August 9, 2013

**Subject: Proposed Truck Loading Area – 56 Milliken Street  
Application ID: 2013-181  
Comments from City of Portland Staff**

FST has received your memos and reviewed the comments (*italicized*) on the above referenced project. Your comments (*italicized*) and our responses (**bold**) are as follows:

DRAWN: CMW DATE: JULY 2013
DESIGNED: RJW SCALE: 1" = 10'
CHECKED: RJW JOB NO. 3215
FILE NAME: 3215-PHOTO
SHEET C-4.0

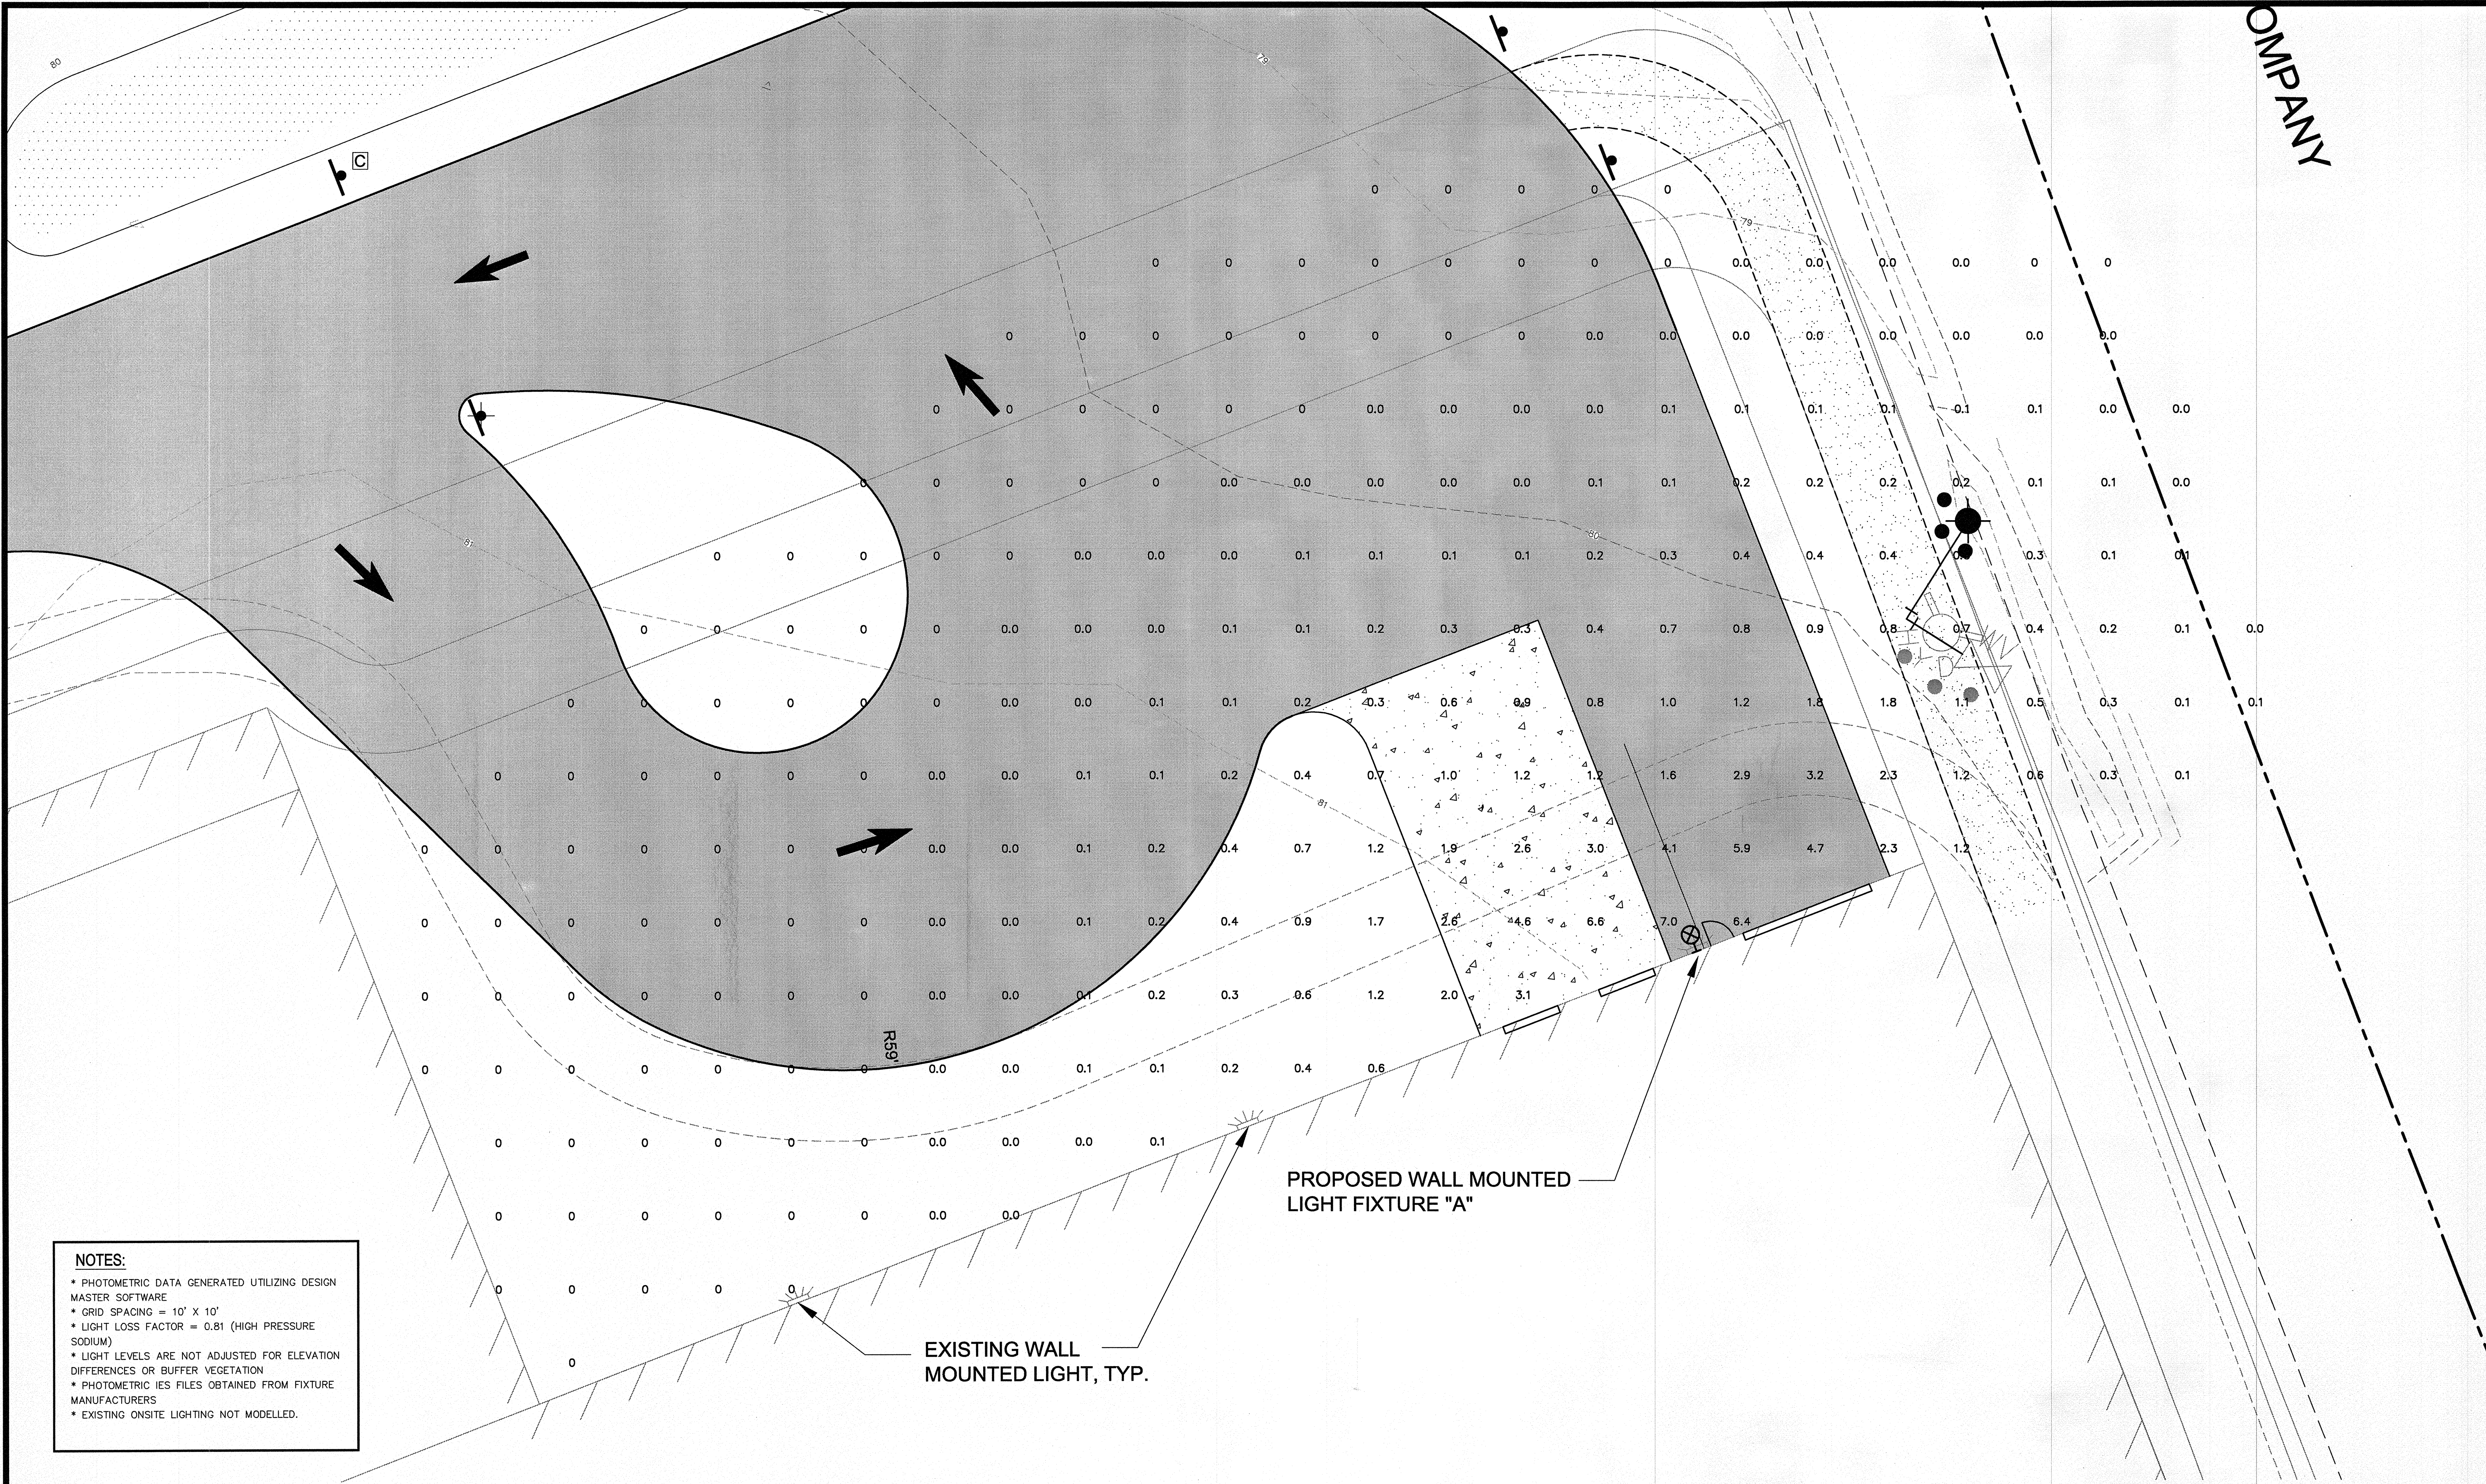
*Will there be any new lighting being proposed? If so, please provide lighting catalogue cuts and show location on site plans. We will also need photometric plans.*

**Sheet C-4.0 is the photometrics plan for the project. This plan only represents the lighting coverage attributable to the new fixtures. A Kim Lighting “wall director” fixture is proposed at the loading dock location. A catalog cut is provided with this letter. We note these are several existing wall mount fixtures along the existing building sidewall. These fixtures provide primarily security level lighting coverage for the relatively isolated site area.**

AT-1

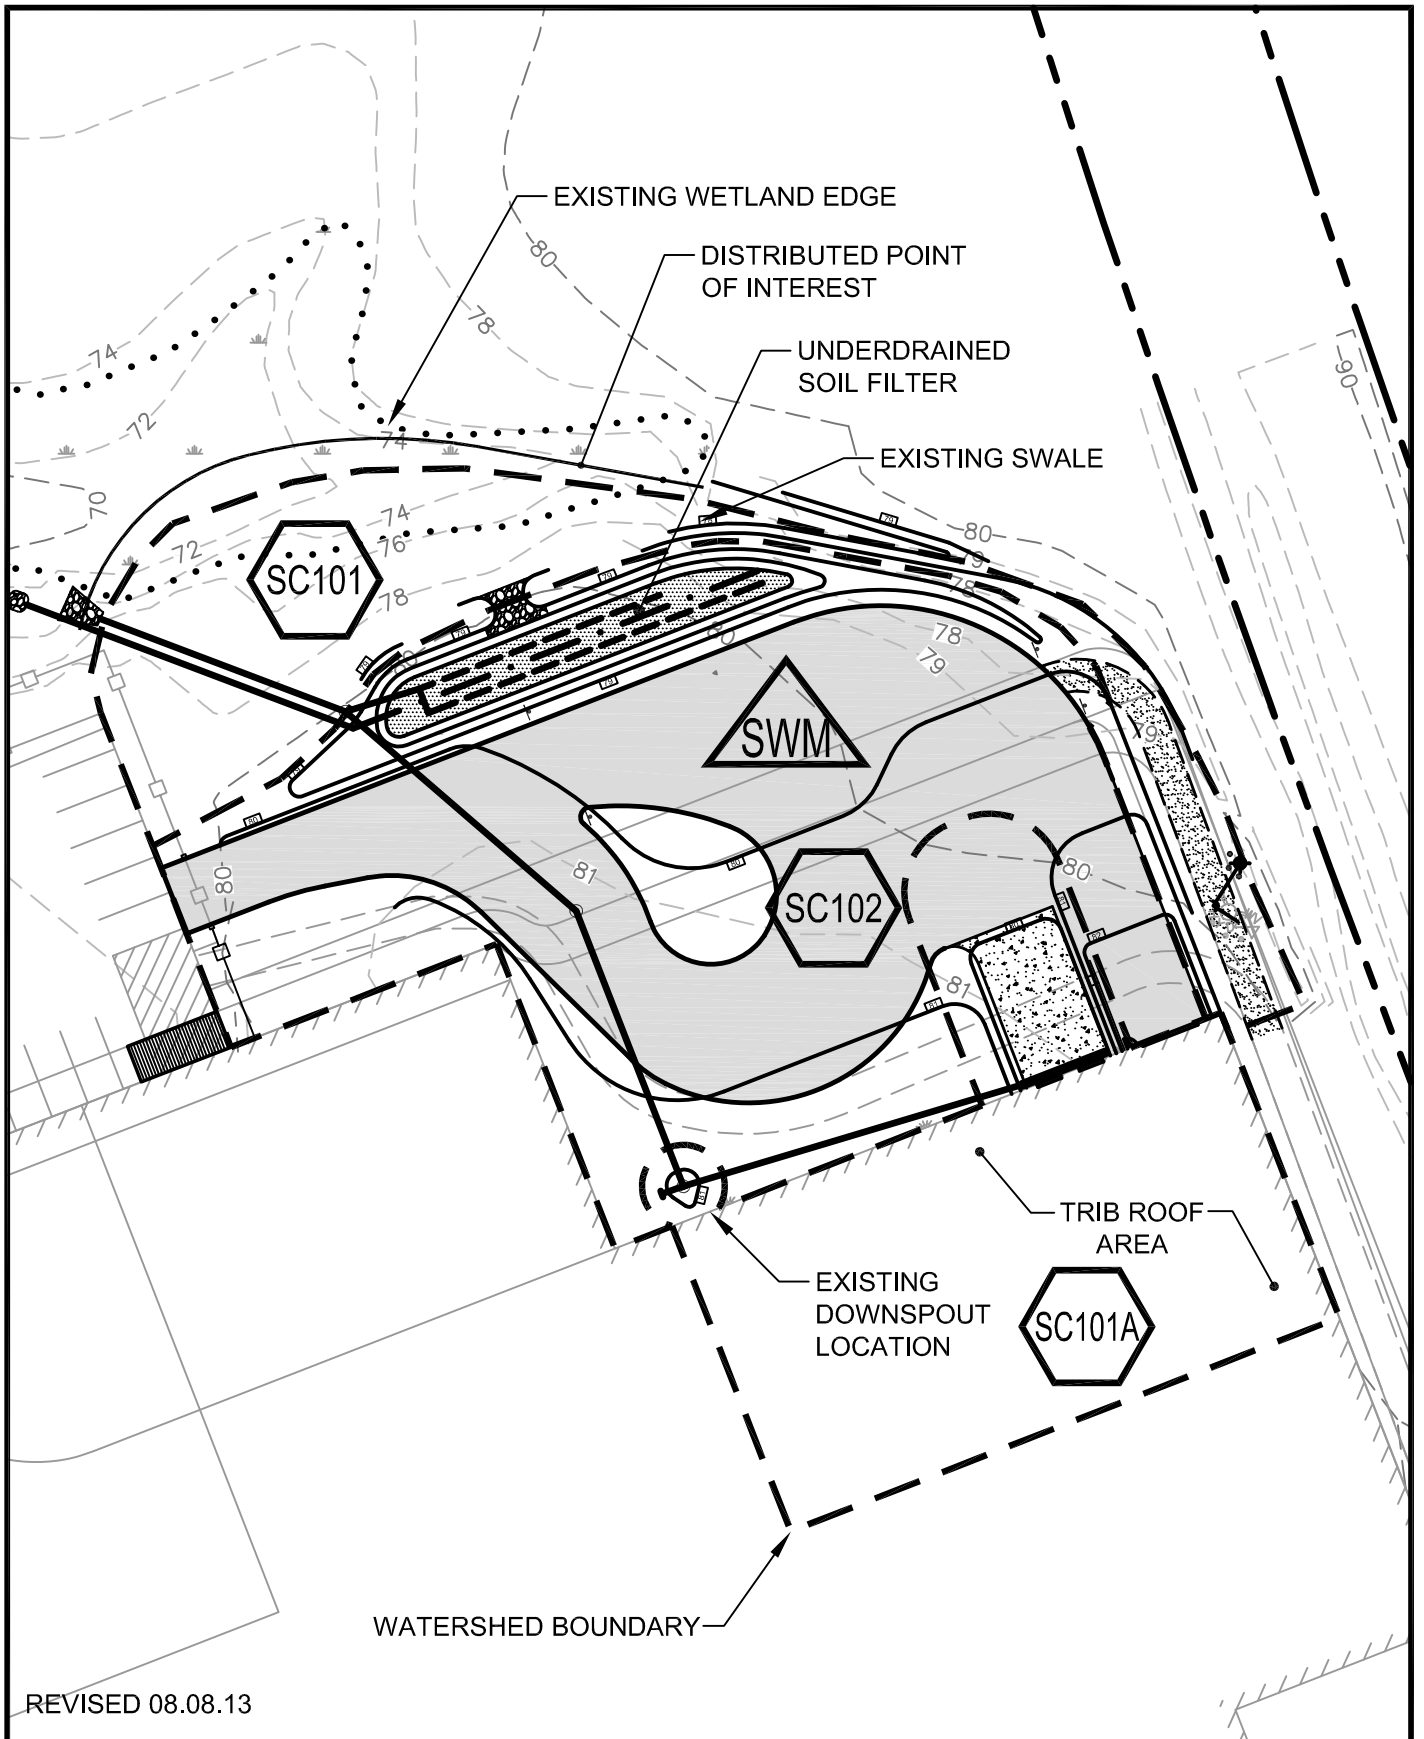
*Is there any options to decrease the impervious area as related to this project?*

*The applicant should provide auto-turn template graphics that support the proposed pavement area. It is suggested that pavement area be reduced if it can work from a truck circulation perspective.*

**Figure AT-1 included with the submission materials shows the AutoTURN movement for the WB-67. The figure shows support for the extent of pavement provided. Ideally, we would have liked to actually provide a greater area for truck maneuvering given the WB-67 design vehicle. However, the applicant has chosen to go with as minimal area as we felt comfortable with particularly given the moderate level of use anticipated for the new docks.**

**See Figure AT-1 included with the original submission materials. This figure shows that the WB-67 design vehicle must maneuver into a 180 degree change of direction before reversing into the loading bays. This is not the most desirable but does eliminate additional pavement that would have otherwise extend out 50 feet or more in front of the loading bays.**

WS-2

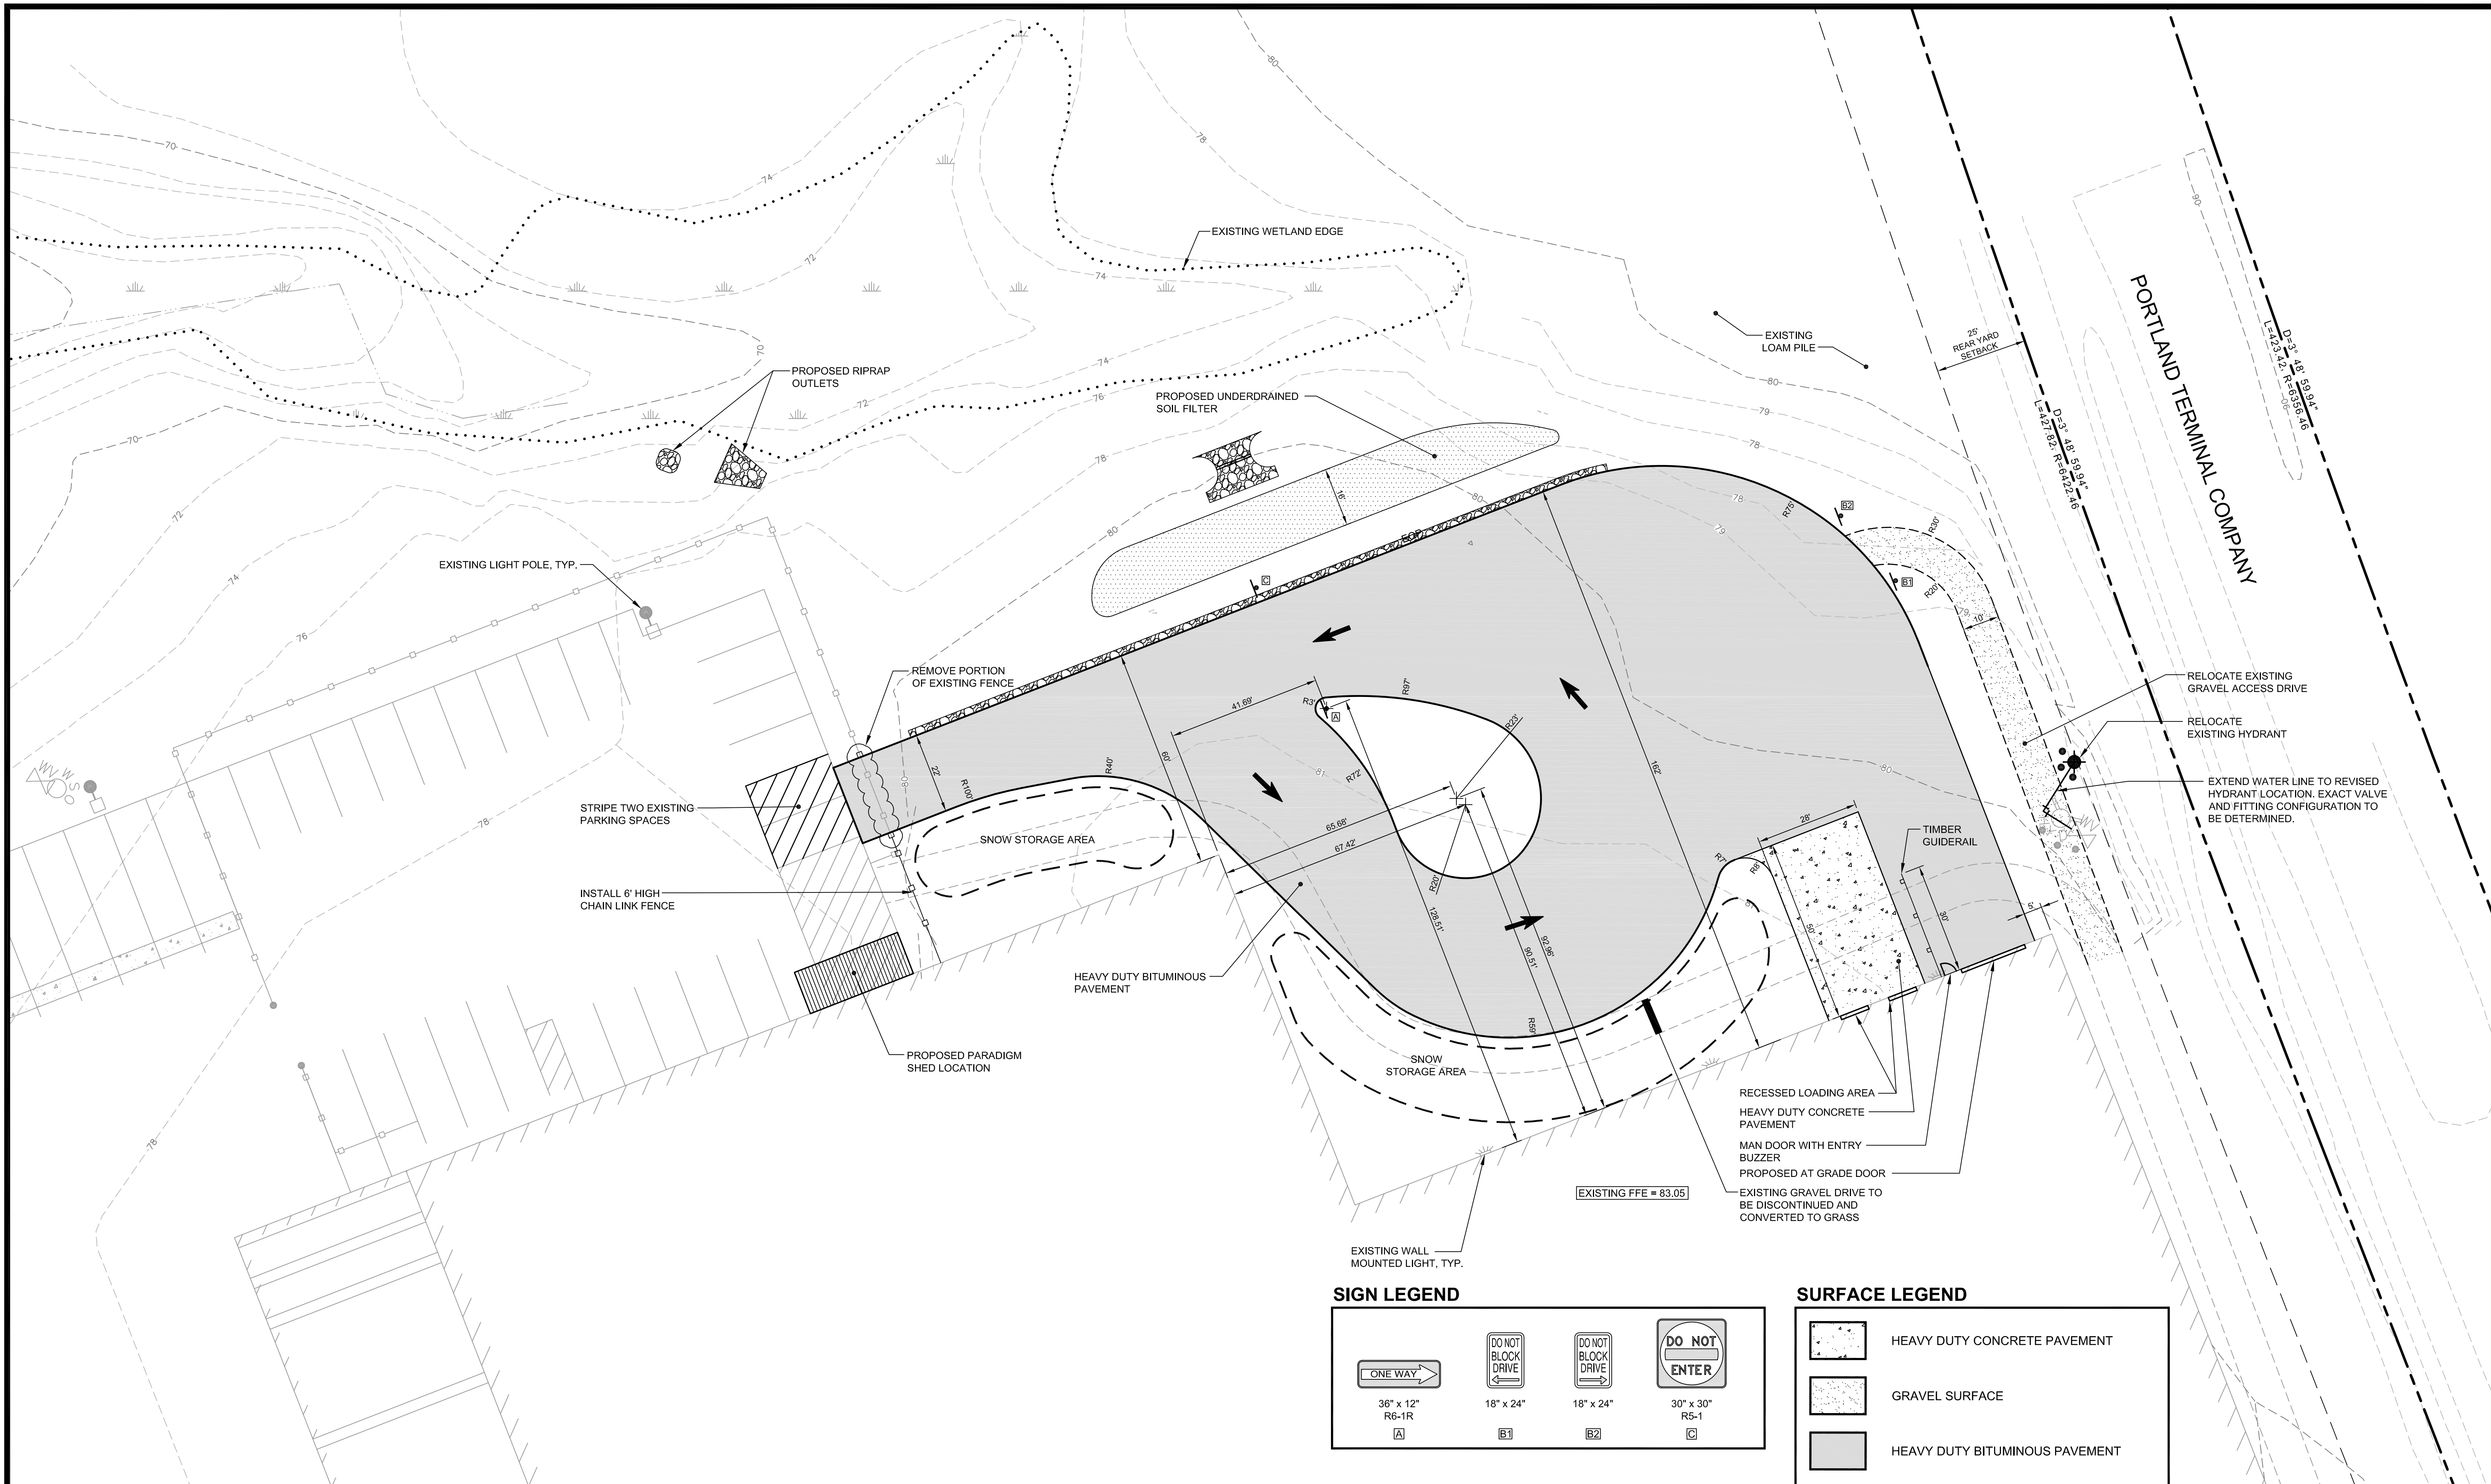
*3) Figure WS2 - Post Development Watershed Map: The SC102 and SC101A boundaries do not appear to reflect the extent of the capture area associated with the proposed loading dock trench drain. If the capture area for the trench drain is greater than currently reflected on the figure, the Applicant shall recalculate the "impervious area treated" number for the project.*

**The WS-2 Map has been revised. No updates to computation were necessary. The revised figure represents the values in the model.**
